Sir Antony Gormley & Antony Gormley Studio, Submission for Deadline 5 – 1st May 2020

Please find below our submission for Deadline 5, 1st May 2020, in answer to the Applicant's responses to the Examining Authority's Second Written Questions, the Applicant's comments on Deadline 3 Submissions, and on relevant additional information submitted in line with Deadline 4.

Drawing file: TR010031 / TR010031-000988-Appendix 1A - A1 BCH Landscape Mitigation - Angel of the North.pdf

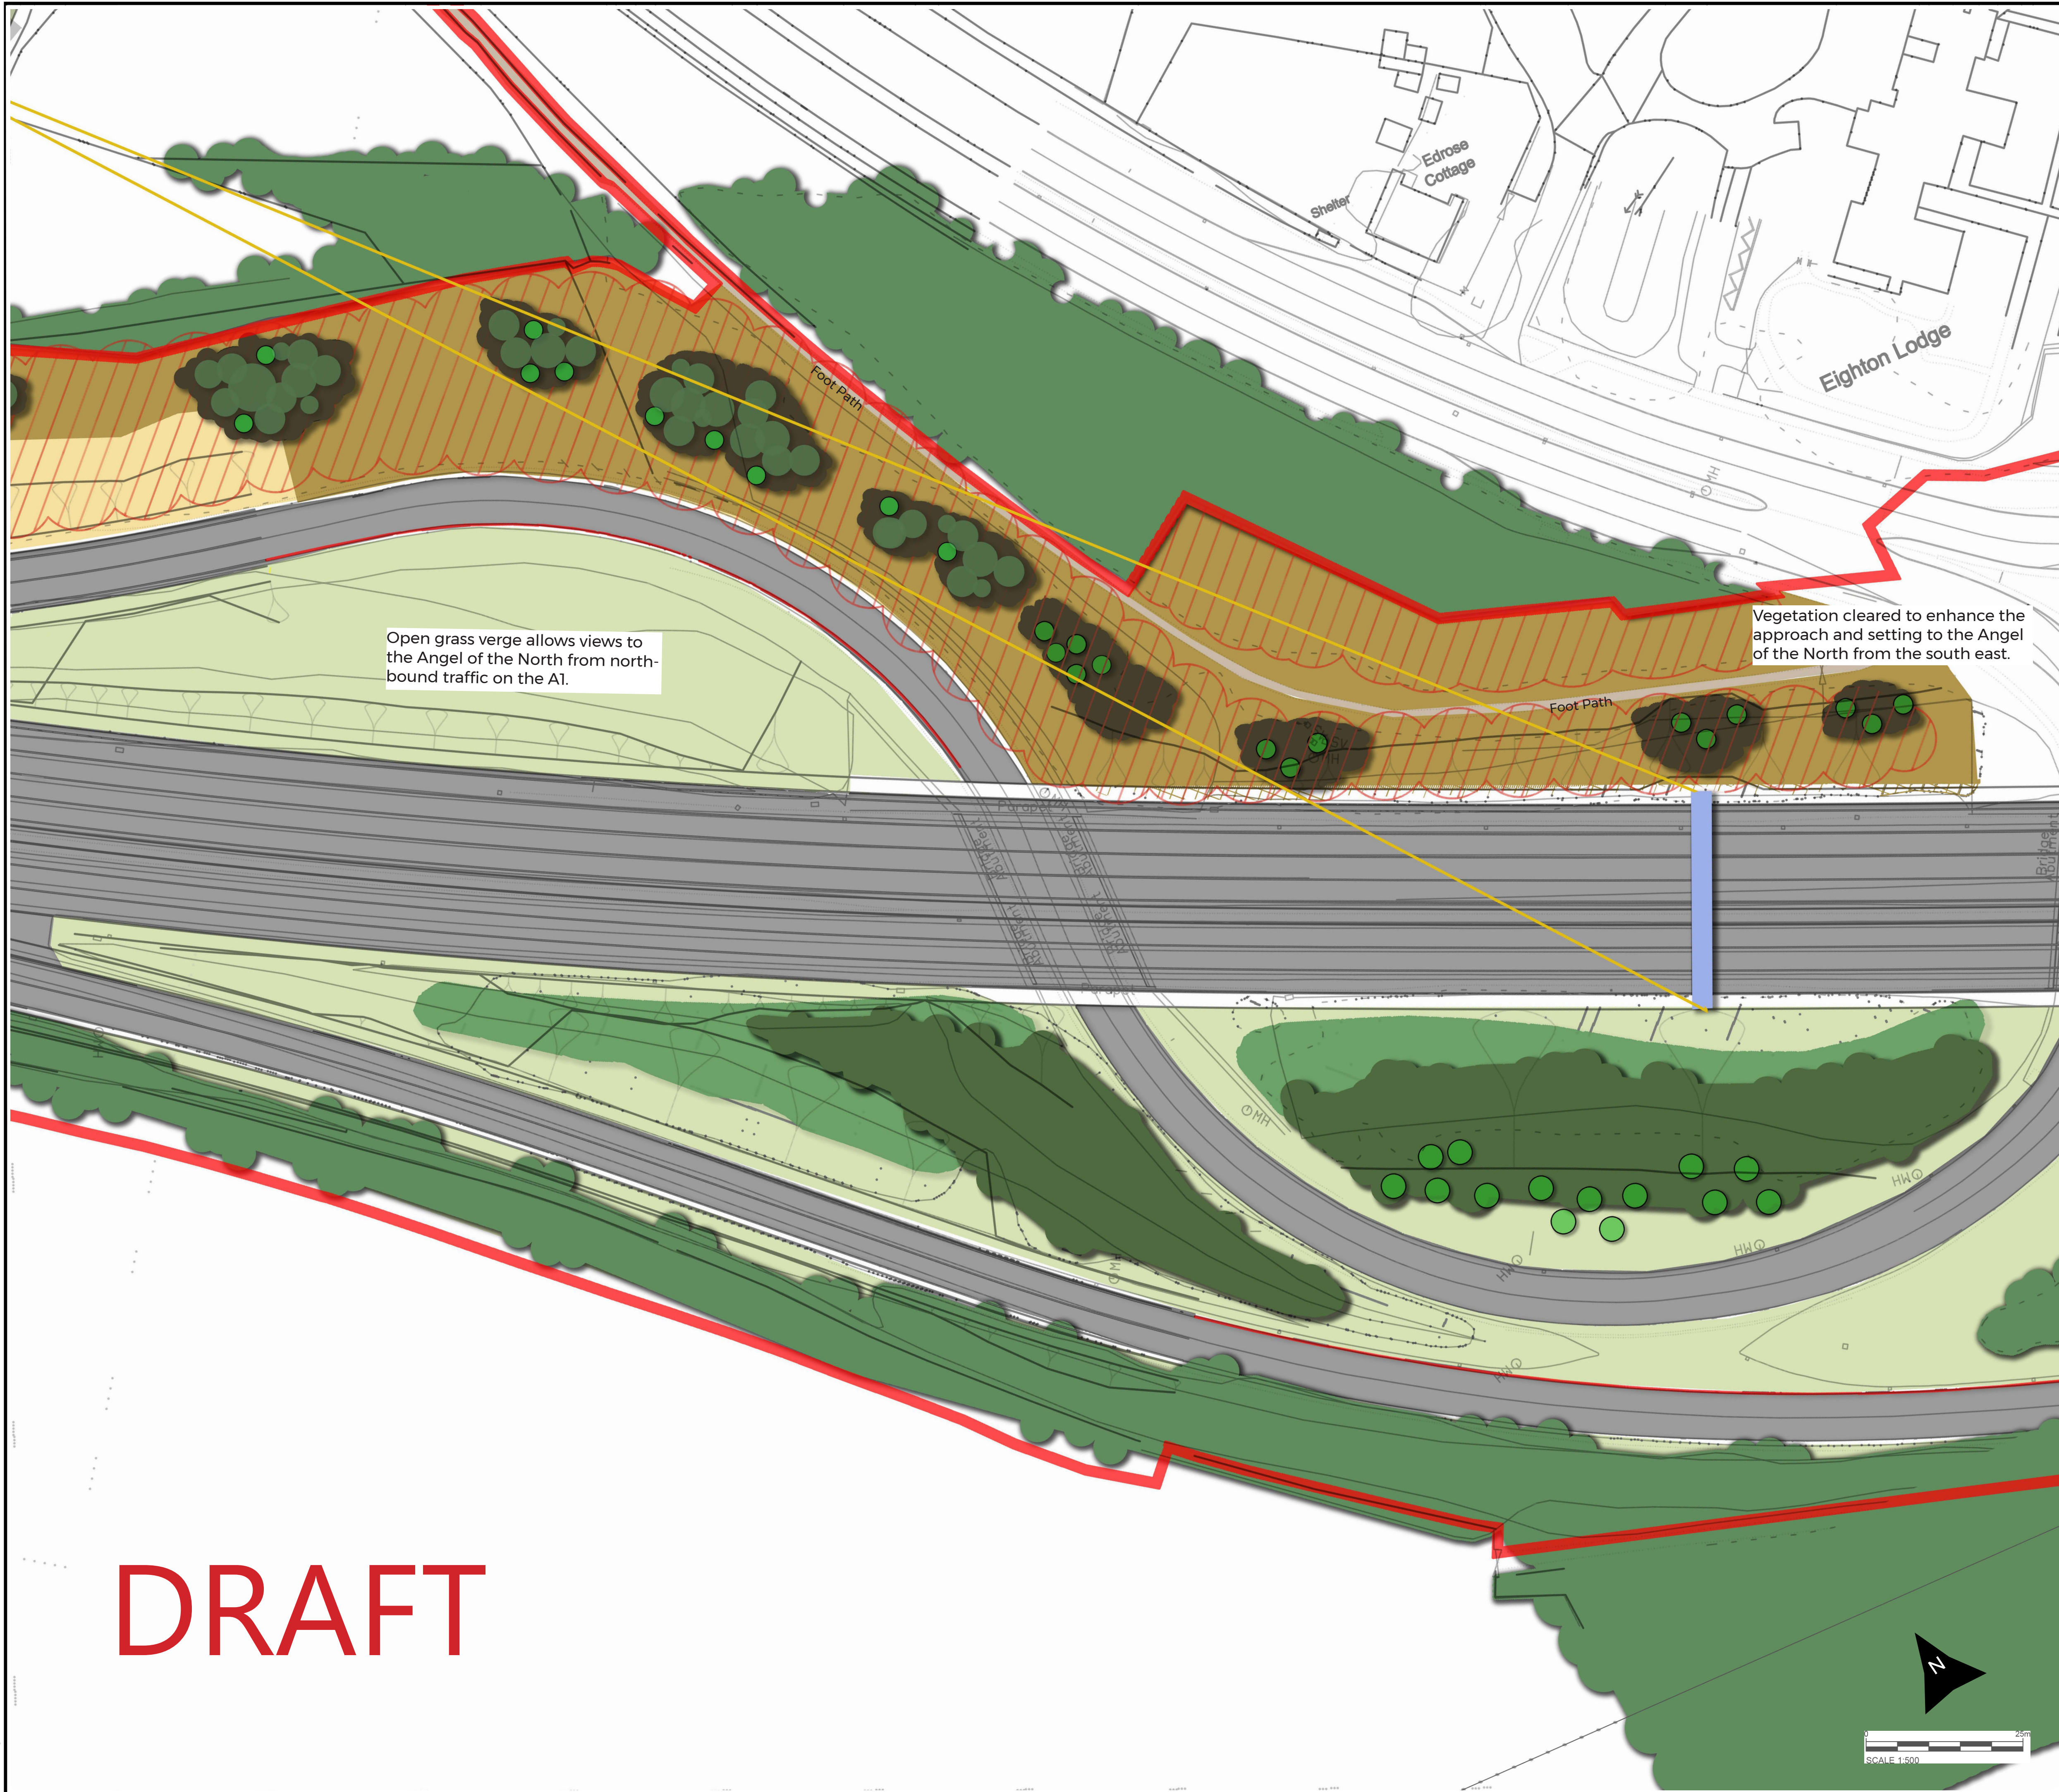
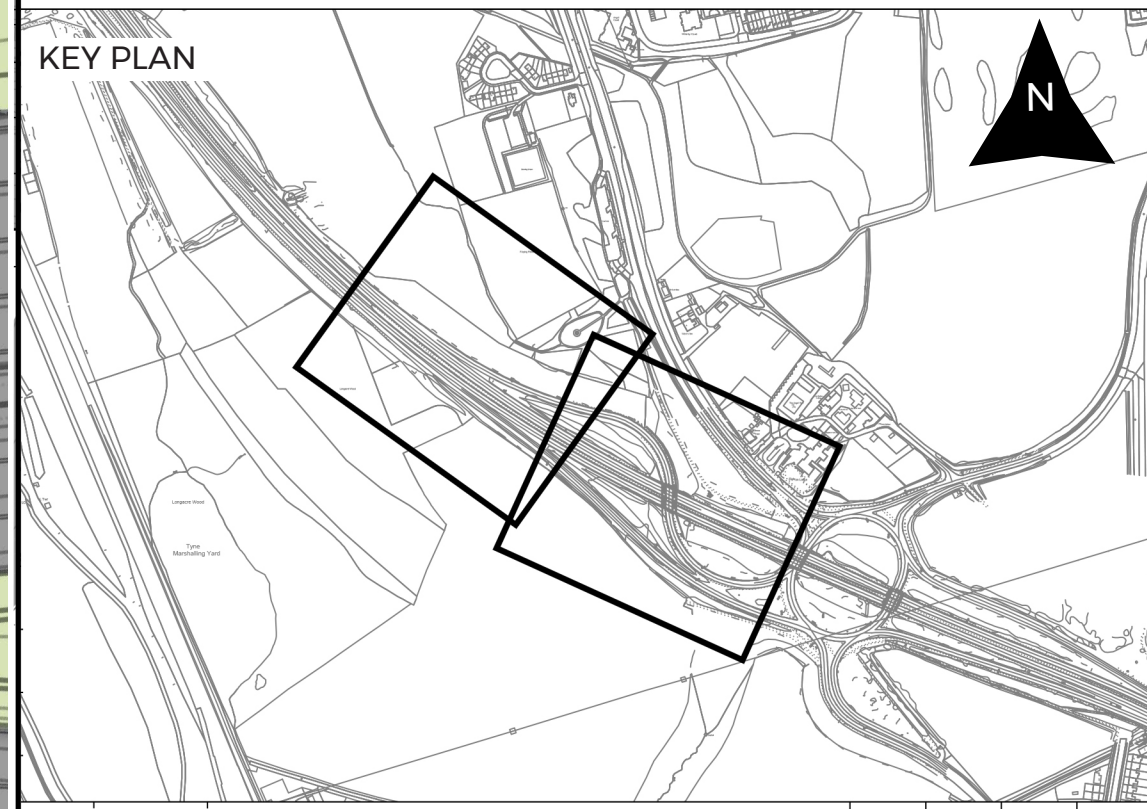
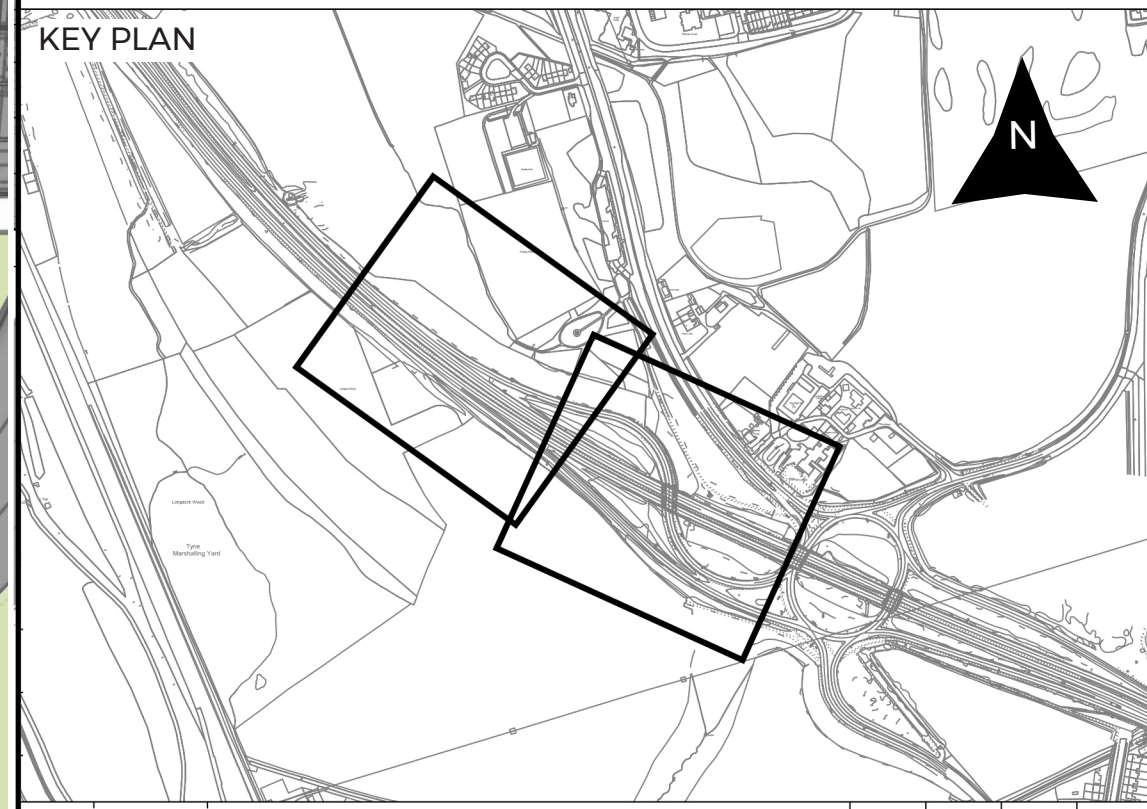
We would like to reinforce the issues raised in Gateshead Council's *Local Impact Report*, and would like more guarantees from the Applicant that, as proposed in *Figure 7.6: Landscape Mitigation Design [APP-061]*, any reduction in views to the Angel of the North are considered and compensated for in the landscape design and mitigation planning. For example, the Applicant has suggested that woodland edge planting between chainage 12300 – 12560 could be less dense to allow greater potential for views to the Angel of the North, but we propose that there are no trees in this area at all, in line with Gateshead Council's commitment to opening up the site to its original configuration.

We understand that the Applicant is currently in conversation with Gateshead Council regarding landscape mitigation plans and vegetation management schemes and welcome a coordinated approach. We would be grateful for any updates on these discussions, and further assurances that the opening up of views to the Angel of the North to minimise the negative effect of gantry placement will be prioritised in these plans.

All visual assessments carried out by the Applicant to date do not factor in the proposed Southern Green Landscaping plan developed by Gateshead Council. This plan aims to reveal more views to the Angel of the North and to manage the now overgrown vegetation that currently surrounds the Artwork.

The conclusions drawn in the Applicant's reports fail to reflect the significant disruption that would be caused by the proposed gantries. The Applicant consistently diminishes the impact of the gantries by referring to current vegetation cover. This is not a representative assessment of the true potential impact. The Southern Green 'Revealing the Angel' scheme embodies our desire, and Gateshead Council's desire, to effectively manage the surrounding vegetation to maximise views of the Angel of the North. The current state of the vegetation is not as intended.
